KITTITAS COUNTY COMMUNITY DEVELOPMENT SERVICES

February 22, 2013

RE: PacifiClean Compost Application, CU-13-00001

DRIVEWAY ACCESS ROAD 1
C105

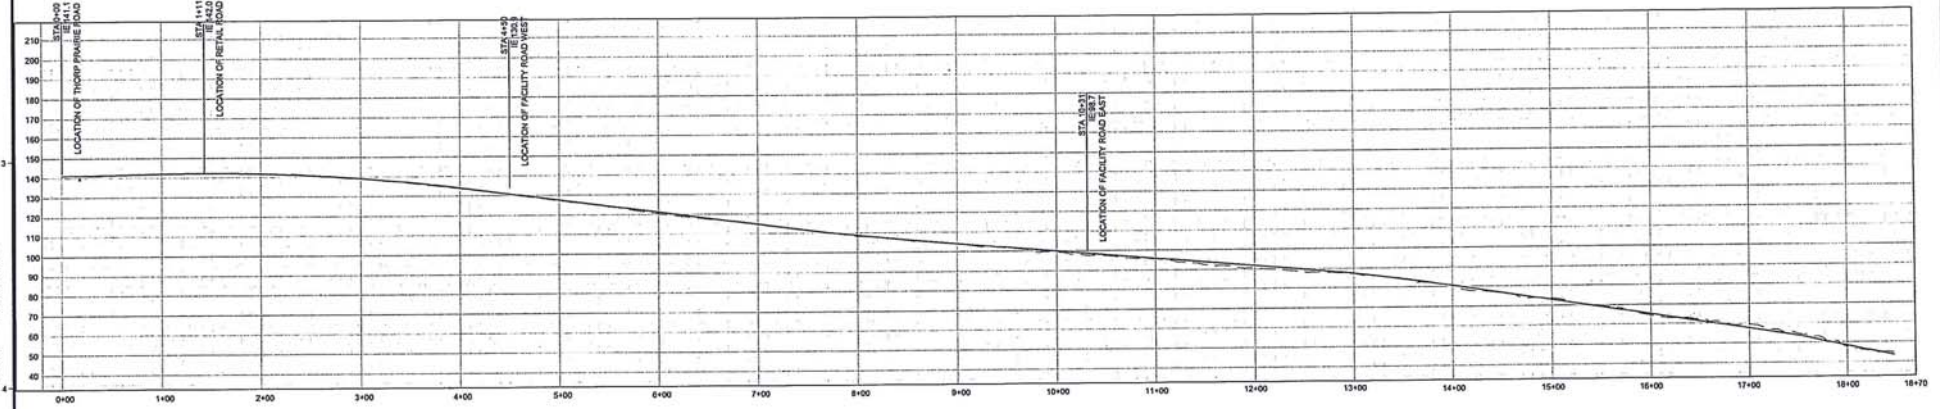
7. Road Construction. The geotechnical report for the access road, Thorpe Prairie Road, is adequate. However, there is no indication in any other report of how the road will be improved and to what standards, how road surface water will be managed, and, as mentioned above, how introduction of heavy vehicles will affect existing roads and traffic.

ELK HEIGHTS ORGANICS PROCESSING SITE

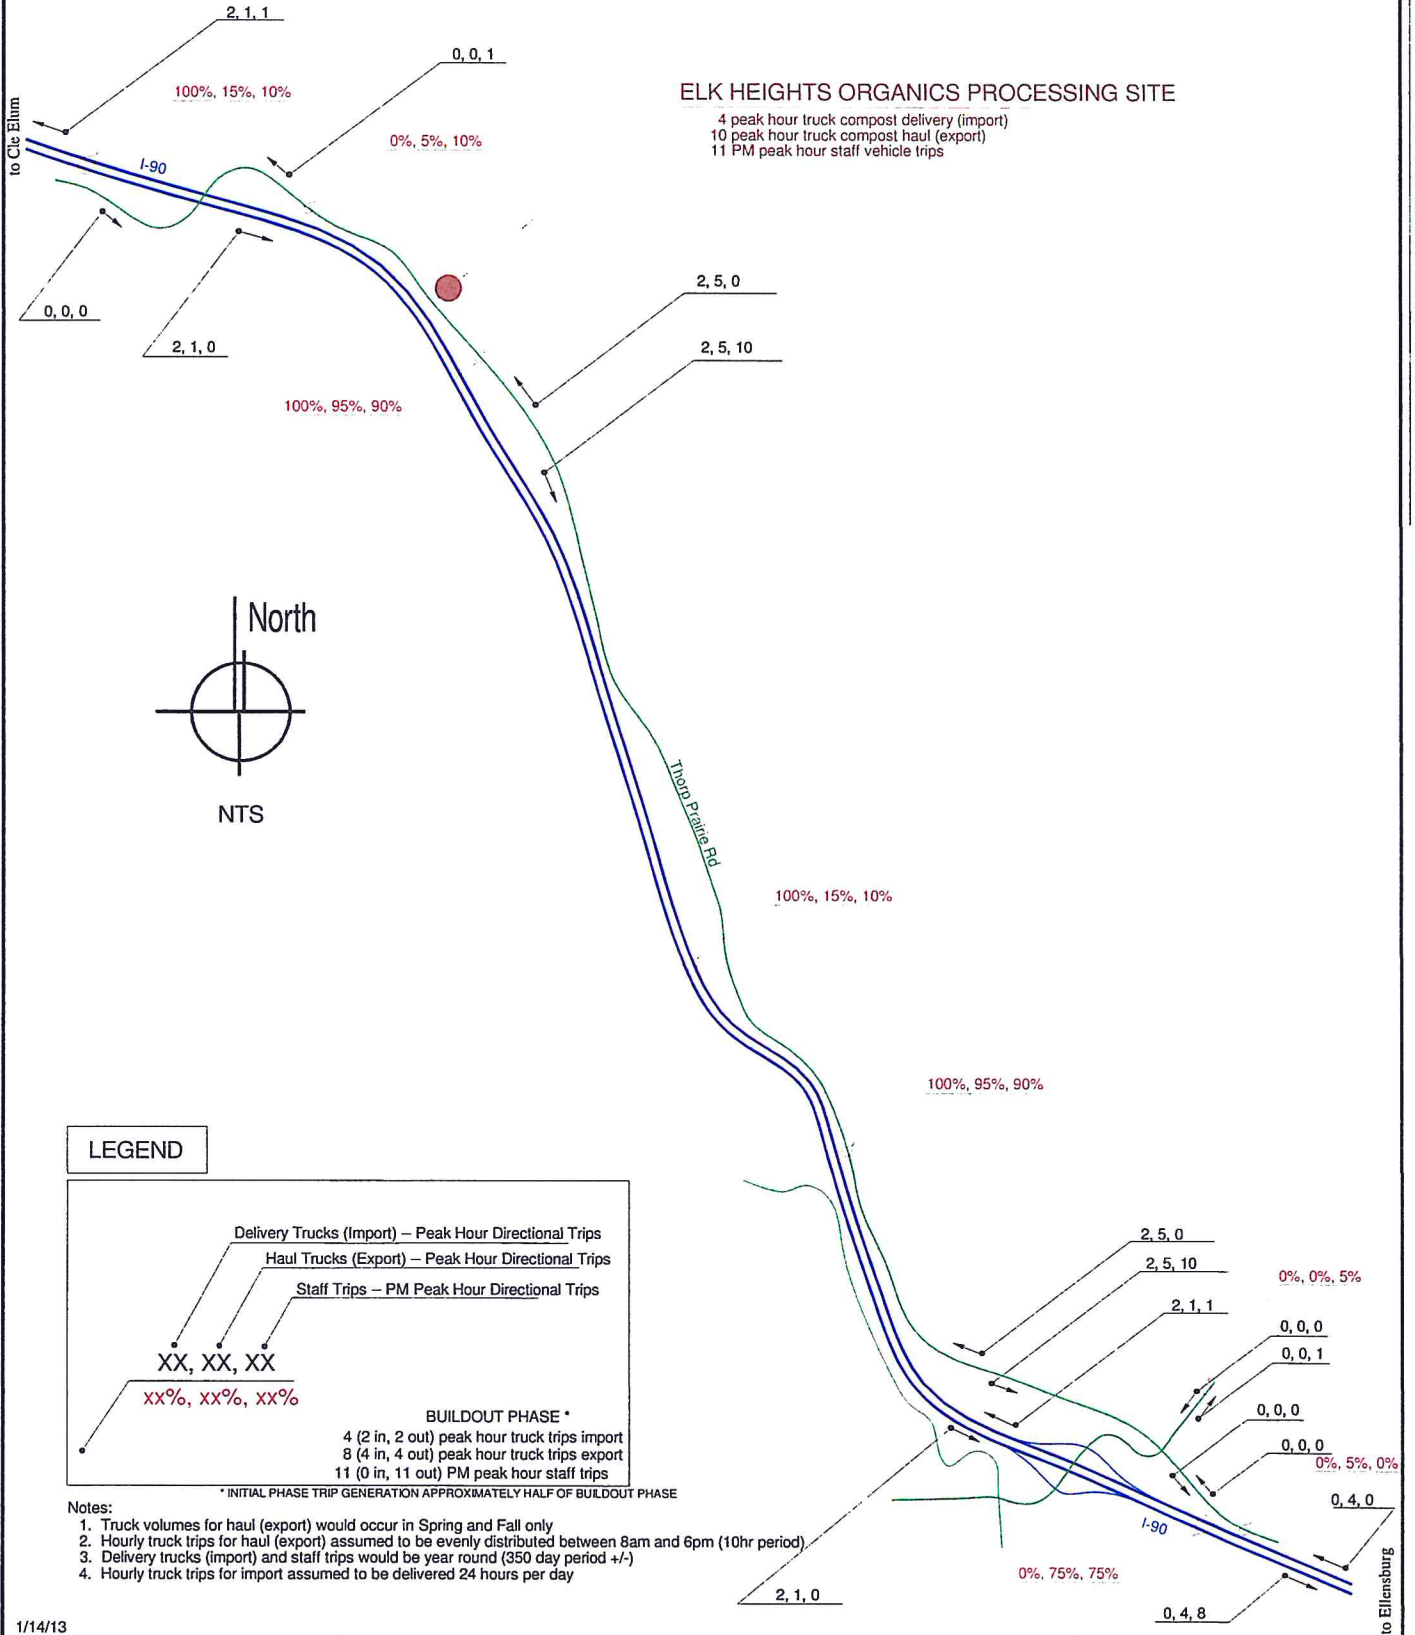
6. Traffic. You have addressed the issues related to the flow of traffic. But the intersection from I-90 to the site has conditions that will have to be mitigated in order to accommodate additional traffic for the size of anticipated vehicles with the least impact upon existing traffic. No analysis has been provided indicating turning patterns of trucks and how much space will be necessary so that a turning truck is not impeding upon the space of a passenger vehicle or other truck moving in the opposite direction within the appropriate lane of traffic. This will have to be provided.

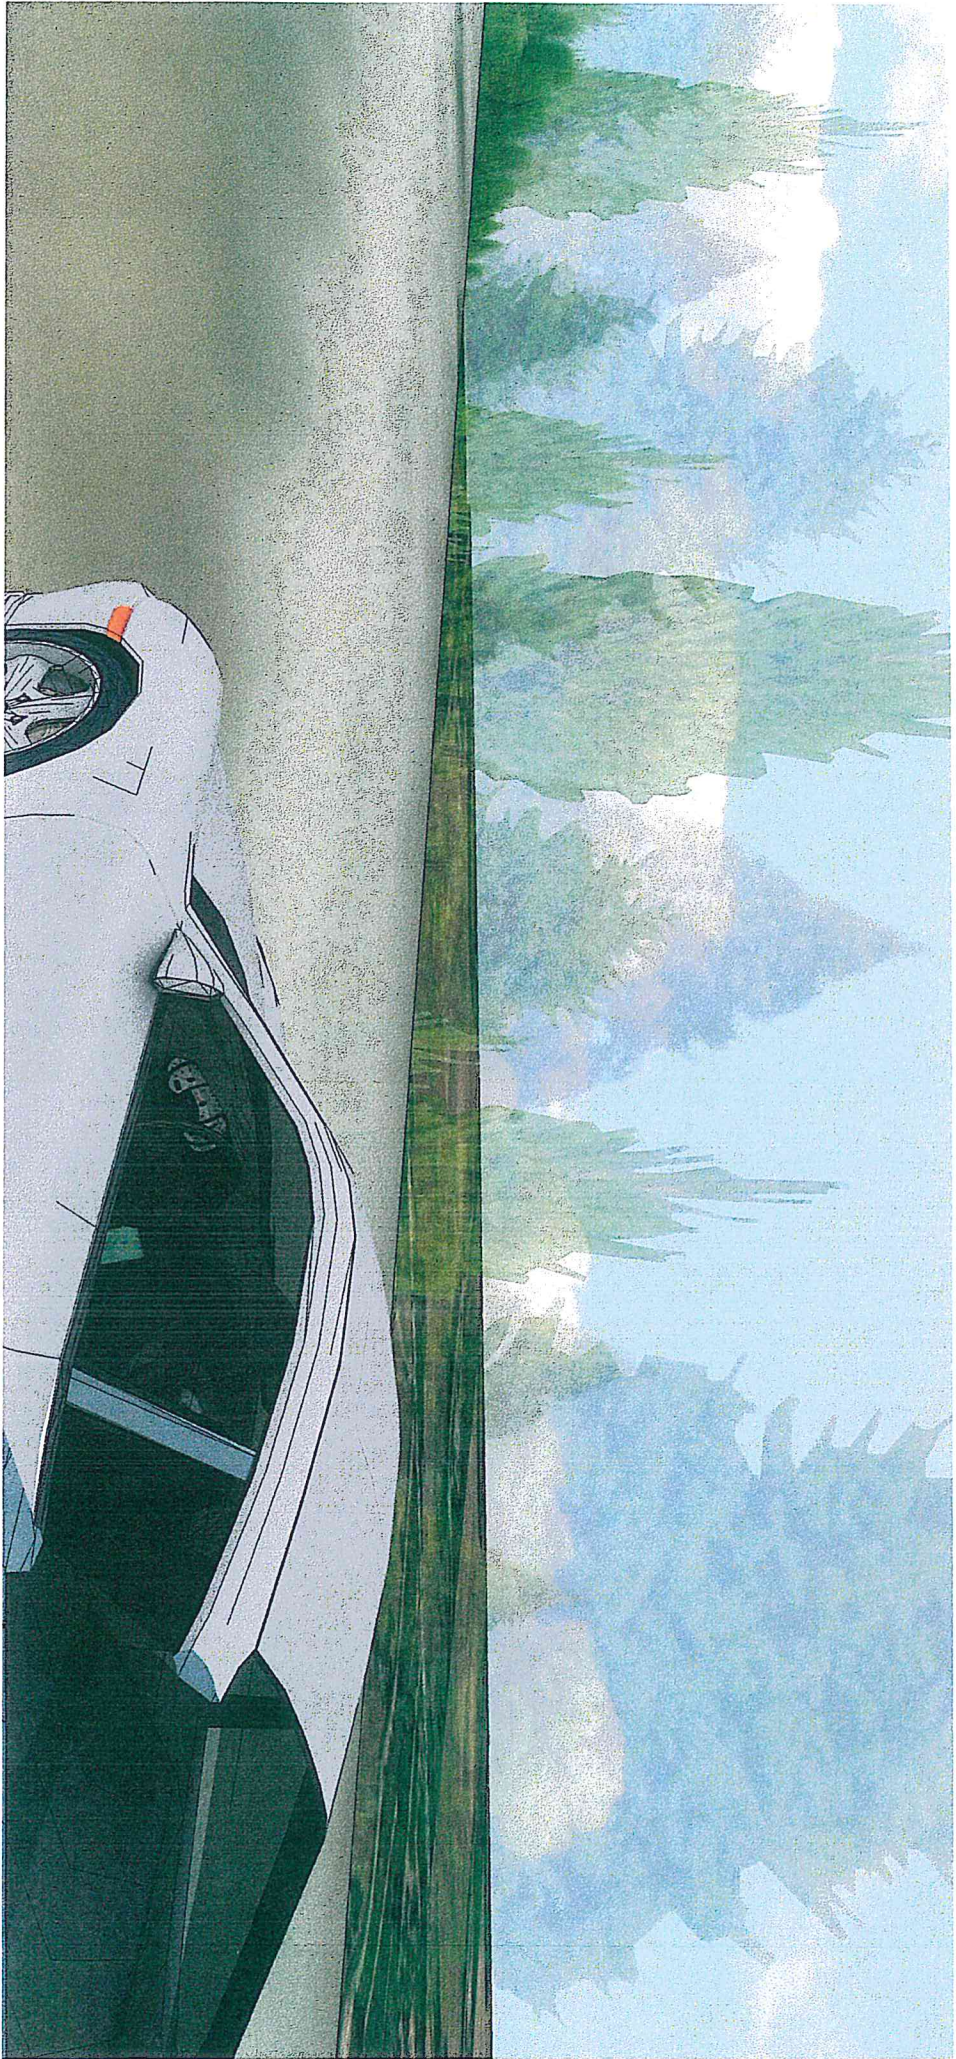
1. **Visual Impact.** While you provided a grade analysis between roads, it is not sufficient to analyze the impact of the site upon view from the road of entry or from I-90. There are no pictures of the site from the roadways and trails from where the operation can be seen. These pictures must have the proposed operation imposed upon the pictures at a minimum in order to determine visual impact and potential mitigation of such impacts. The project is proposed along the "Mountains to Sound Greenway Scenic Byway" and the visual impact of the proposal upon this scenic route will have to be investigated in much greater detail. Analysis should be made from several points along I-90 east and west bound lanes, the Thorpe Prairie Road, and the John Wayne Trail.
